# CITY OF PORTLAND BUILDING PERMIT

414 FORE ST

**PERMIT ID:** 2013-01232

has permission to **Change of use from retail to restaurant - two floors - Wharf St. and Fore St. levels - fit up space including seating, bars and kitchen and equipment, new ADA bathrooms. Change of Use only (no construction) floors 3, 4 & 5 (5 mezz) to 2 Dwelling Units**

ROOF FRAMING PLAN,
NOTES AND DETAILS

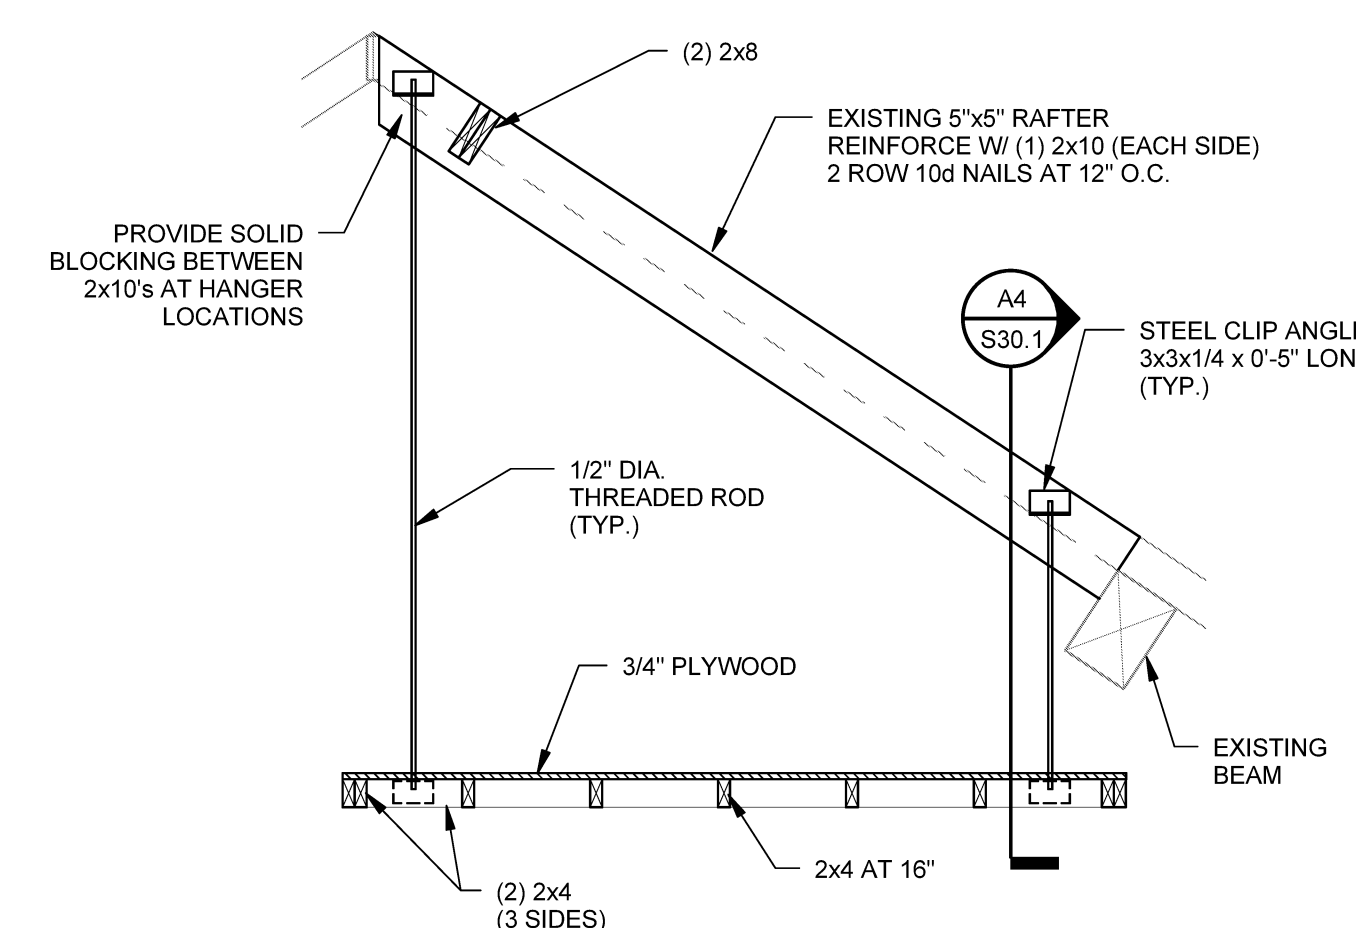
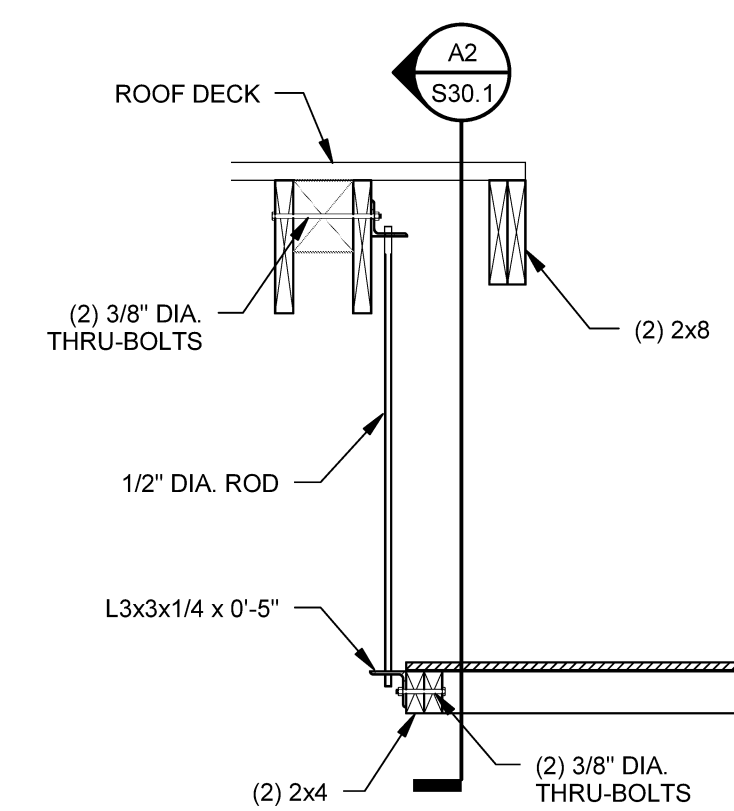
1) Approved with the understanding that the roof railing is not required and has been eliminated from plans.				
2) Door details submitted to staff on 10/4/13 to be revised to include recessed panel, rather than raised panel. Molding around glass to match molding around recessed panel.				
<b>Dept:</b> Zoning	<b>Status:</b> Approved w/Conditions	<b>Reviewer:</b> Ann Machado	<b>Approval Date:</b> 06/20/2013	
<b>Note:</b>		<b>Ok to Issue:</b> <input checked="" type="checkbox"/>		
<b>Conditions:</b>

9) Approval is per the architects recommendation and per IBC 2009 Section 3409 for Historic Structures to exempt the guard for roof access to service mechanical equipment in lieu of federal OSHA standards for tie off requirements.
